**From:** [REDACTED]  
**To:** [REDACTED]  
**Subject:** FW: 2021/1090 Barnsley West (residential & community hub)  
**Date:** 05 March 2024 16:11:27  
**Attachments:** [stretches of overdominance of front of dwelling parking.pdf](#)  
[One bedroom property example current planning applications Nov 23.pptx](#)  
[One bedroom property example in Sheffield.docx](#)  
[image012.png](#)  
[image013.png](#)  
[image015.png](#)  
[image016.png](#)  
[image017.png](#)  
[image018.png](#)  
[image019.png](#)  
[image020.png](#)  
[image021.png](#)  
[image003.jpg](#)  
[image006.jpg](#)  
[image010.jpg](#)  
[image011.jpg](#)  
[image001.png](#)  
[image002.png](#)  
[image004.png](#)  
[image005.png](#)  
[image007.png](#)

**From:** King , Nicholas (SENIOR URBAN DESIGN OFFICER) <[REDACTED]>  
**Sent:** Tuesday, March 5, 2024 11:42 AM  
**To:** [REDACTED]  
**Subject:** 2021/1090 Barnsley West (residential & community hub)

Here are the urban design comments on planning application 2021/1090, following the amendments dated October 2023. Apologies for the delay in sending.

-  
These comments are principally based on Rev 'O' of the Planning Layout for Phase 1.

BARNESLEY WEST PHASE 1 |

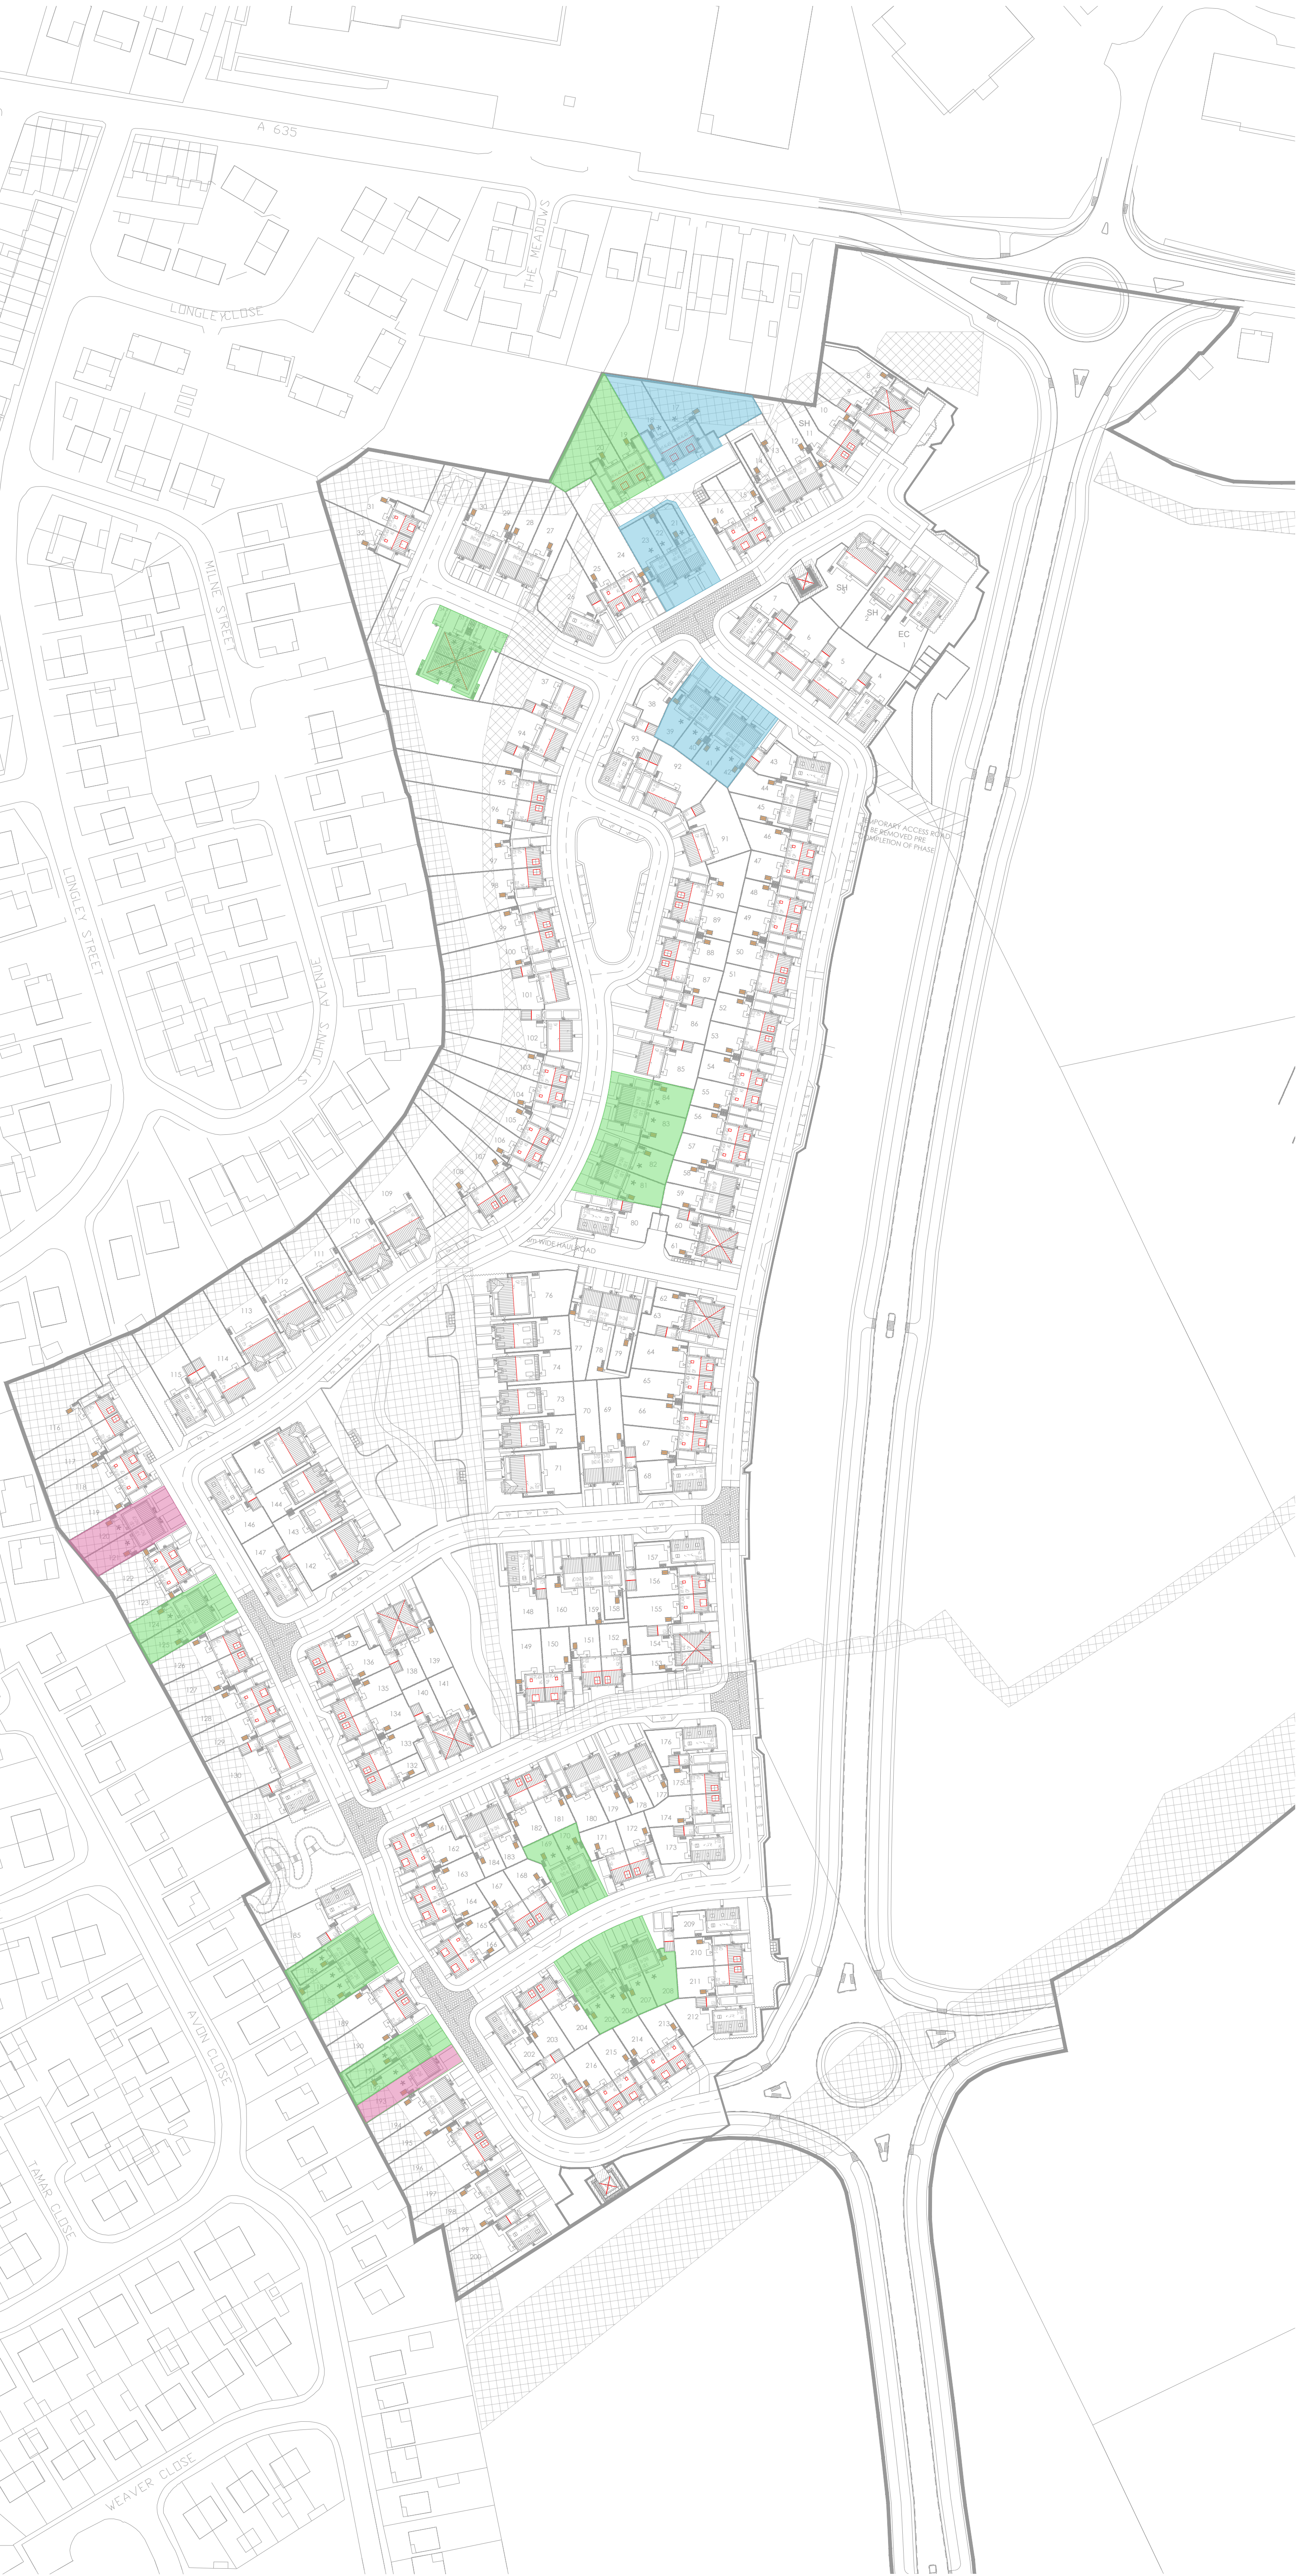
Further to my previous comments, the over dominance of front of dwelling parking is still occurring in parts of phase 1 of the residential development.

Parts of the layout are over dominated by front of dwelling parking. The SPD 'Design of Housing Development' states in para 11.3 '*Continuous strips of front of dwelling parking are not acceptable*' and in para 11.4 '*The maximum number of front of dwelling parking spaces acceptable in a row is four. These should be used sparingly in a development and be separated from other parking spaces by a considerable width of soft landscaping, i.e. more than the width of a parking space.*'

I have attached an annotated layout plan which shows 7 stretches of overdominance of front of dwelling parking.

I note the retro-fitting of visitor parking spaces to meet the requirements of the SPD 'Parking'. I have an objection to the inclusion of visitor spaces on the third side of the triangular public open space on the other side of the road of plots 98 and 99. Previously, (on Rev 'M' of the Planning Layout for Phase 1), this triangular POS had visitor parking spaces shown on two of its sides, both sides located away from the main access road side, so they were relatively less visible. However, the addition of visitor spaces onto this third side of the triangle significantly degrades the quality of this space as public open space.

I do not support the inclusion of a 'quarter house' one bedder dwelling on plots 33-36. 'Quarter house' one bedders give a poor quality of internal and external residential amenity. With regards to internal residential amenity they can be rather claustrophobic inside and they do not give sufficient cross-flow ventilation. I note that plots 34 and 35 have no front views of the road, and the view from the windows of plot 35 will be of close boarded fencing at close proximity. Plots 34 and 35 would be more prone to burglary as none of their doors or windows are overlooked from the street. I don't know how external wheelie bins would be stored in this arrangement, (Barnsley currently has four wheelie bins per property). I think there is a risk that the wheelie bins will be permanently stored by the roadside. There is no sense of a contained private external space at the rear for the occupant's amenity.

I note that the planning layout Revision 'M' showed four dwellings arranged as semi-detached properties, with individual rear gardens. I think this would be a much better arrangement if it could be replicated for the affordable accommodation. I have attached some examples of alternative formats of providing one bedroom dwellings, one a current planning application in Barnsley and one as built in Sheffield, so I would suggest that these alternative formats are considered.
